Rezoning Transportation Analysis

Petition Number: 2020-121

General Location Identifier: Tax ID (07110402)

Revision Log:

RZ-1.0

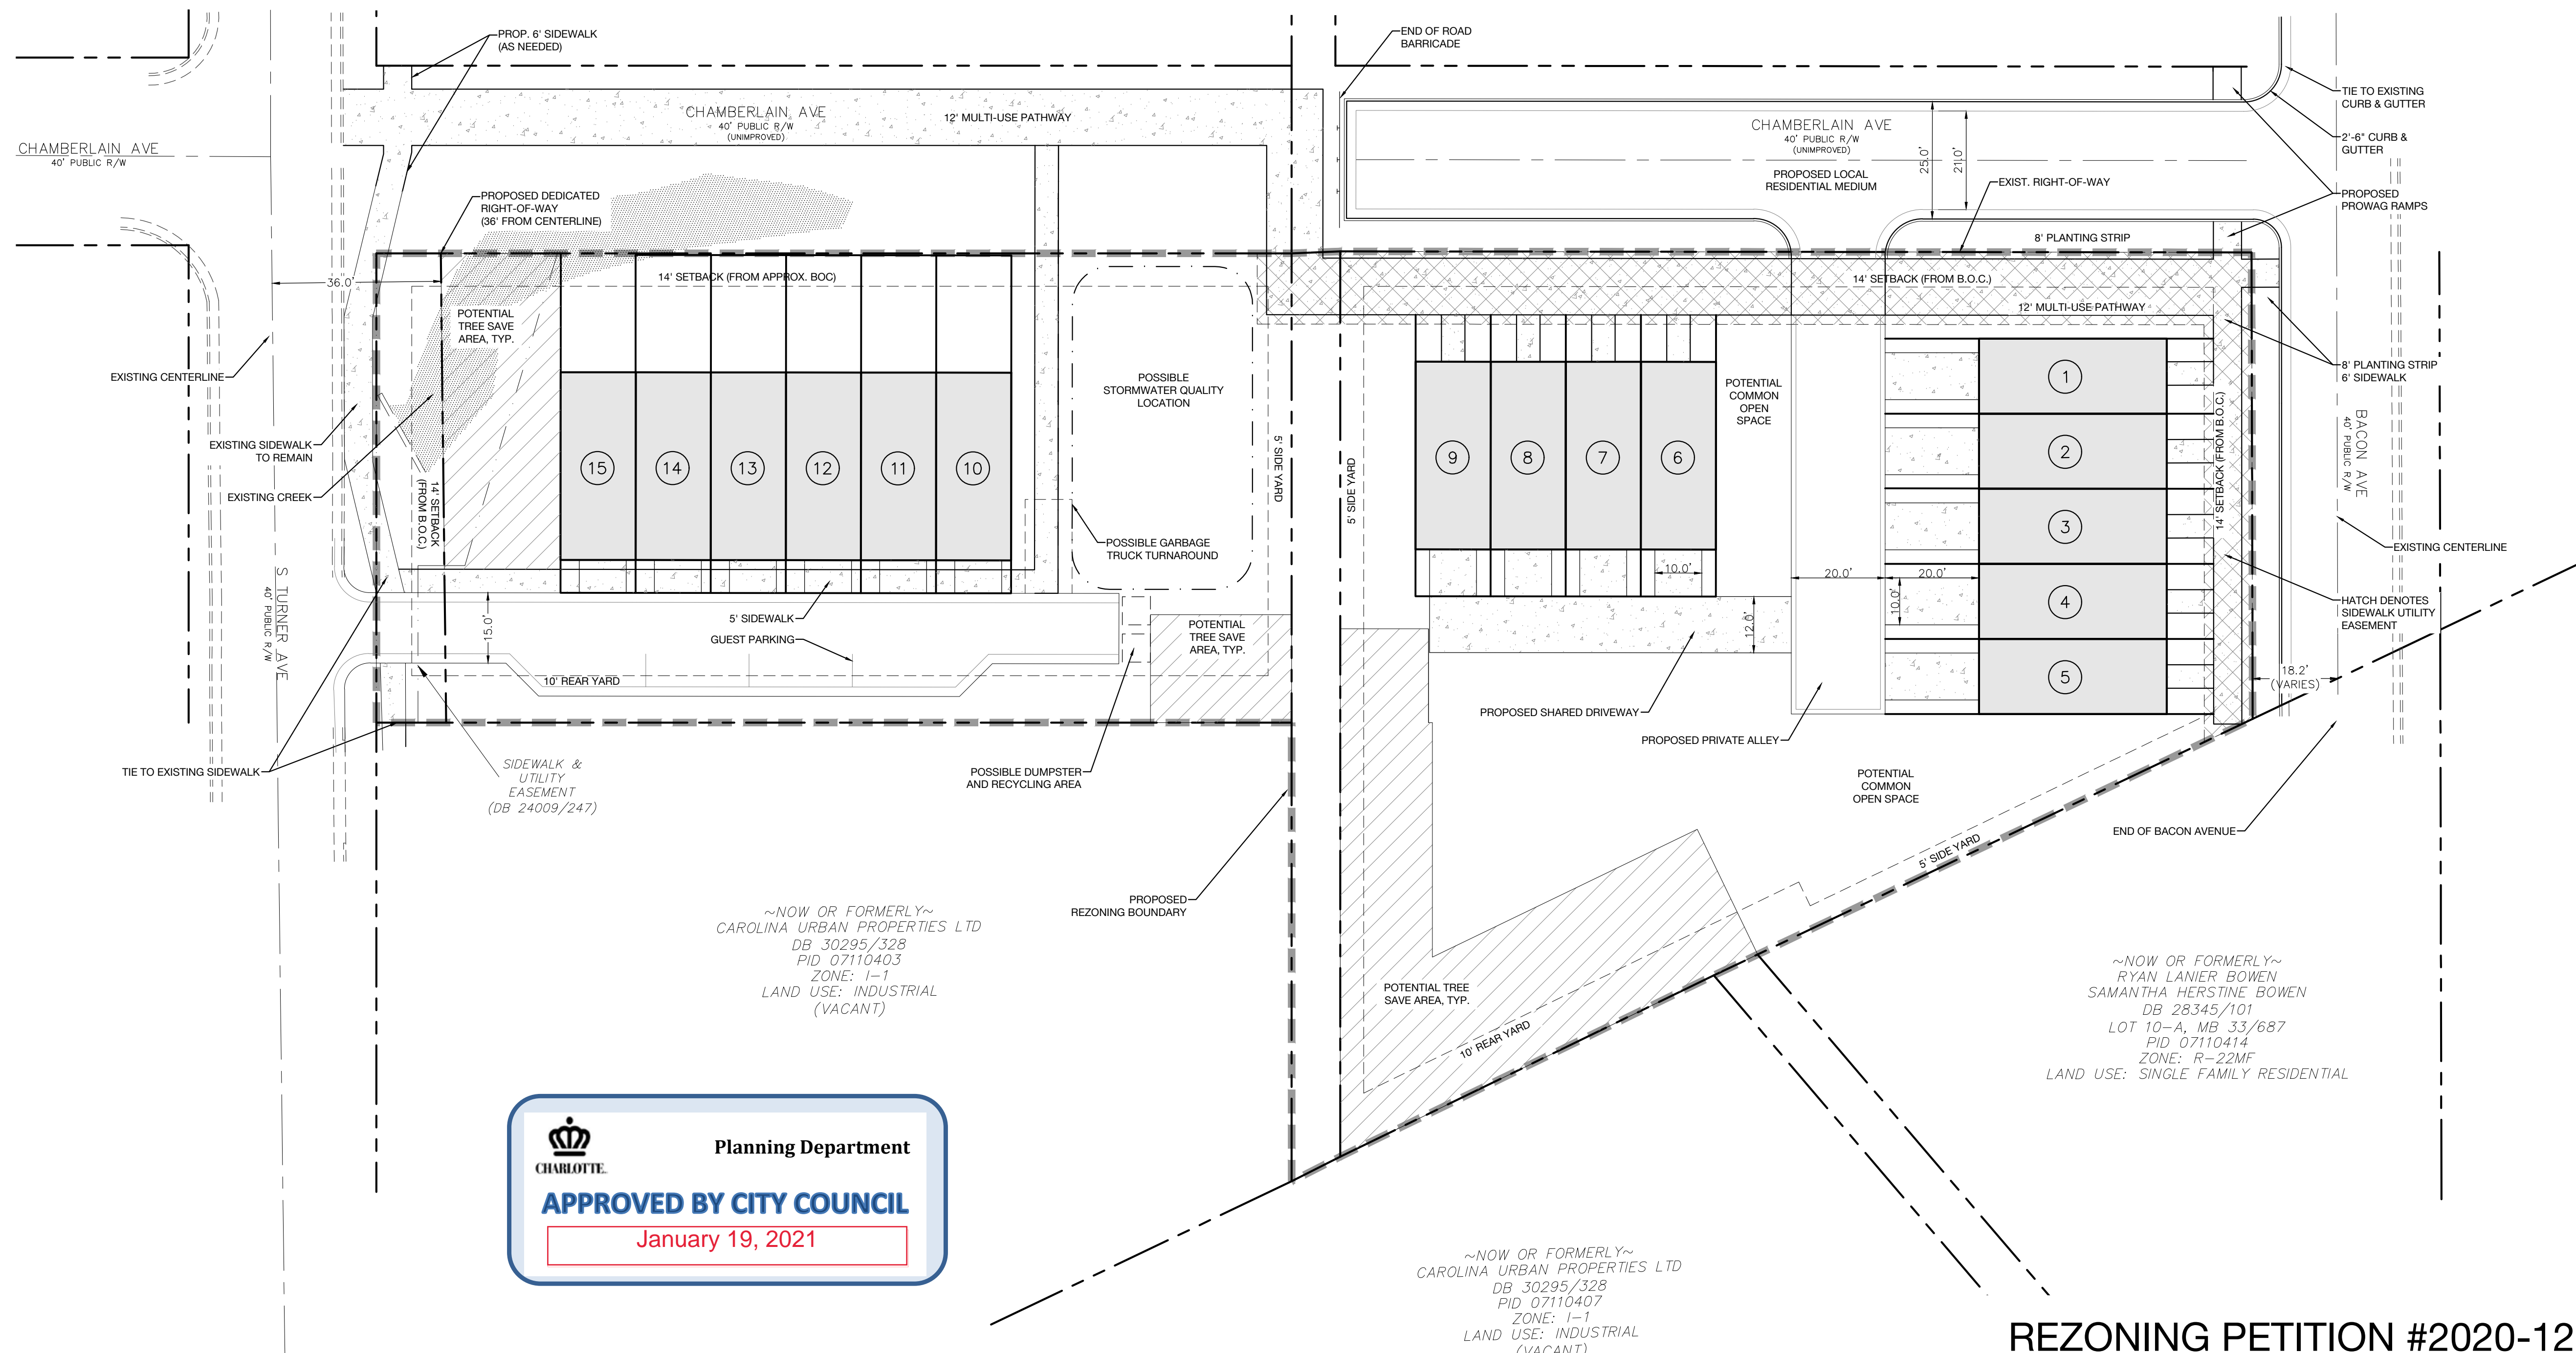
- ~~3. Revise the site plan and conditional note(s) to commit to dedicate 36-feet of right-of-way from the Turner Avenue road centerline, labeled and dimensioned from the road centerline, in accordance with Charlotte Land Development Standards Manual (CLDSM) Urban Street Design Guidelines (USDG) standard detail number **U-07 – Local Collector Street Typical Section**.~~

- ~~4. As per discussions with the Charlotte Planning Subdivision Group, the Chamberlain Rd. connection is required, but due to site constraints, a Multi-Use Path is being substituted for the completed street.~~

- ~~5. Revise the site plan and conditional note(s) to provide two PROWAG ramps per intersection corner, at the intersection of Chamberlain Avenue and Bacon Avenue, if roadway is constructed within the Chamberlain Avenue unmaintained right-of-way.~~

- ~~6. Revise the site plan and conditional note(s) to tie-in the proposed multi-use path at the Turner Avenue and Chamberlain Avenue intersection.~~

- ~~7. Revise the site plan to add a note specifying dedication and fee simple conveyance of all rights of way to the City before the site's first building certificate of occupancy is issued. CDOT requests right of way set at 2' behind back of sidewalk where feasible.~~
- ~~8. Revise the site plan to add a note specifying all transportation improvements will be approved and constructed before the site's first building certificate of occupancy is issued. The petitioner may phase transportation improvements if said improvements and phasing are explicitly described in site plan notes.~~
- ~~9. To attain a street and pedestrian lighting recommendation, the petitioner should coordinate with Anthony Mendez, CDOT. Please visit the following link:
<https://charlottenc.gov/Transportation/Programs/Pages/StreetLighting.aspx>~~
10. **Resolved** Sample format for comment that is resolved

The site is located on Turner Avenue, a collector road. The petitioner is providing a 12' shared use path and an 8-ft planting strip and 6-ft sidewalk along Bacon Avenue, with accessible ramps. The existing sidewalk along South Turner Avenue will remain. The petitioner will also dedicate additional right-of-way along South Turner Avenue. All CDOT comments have been addressed.
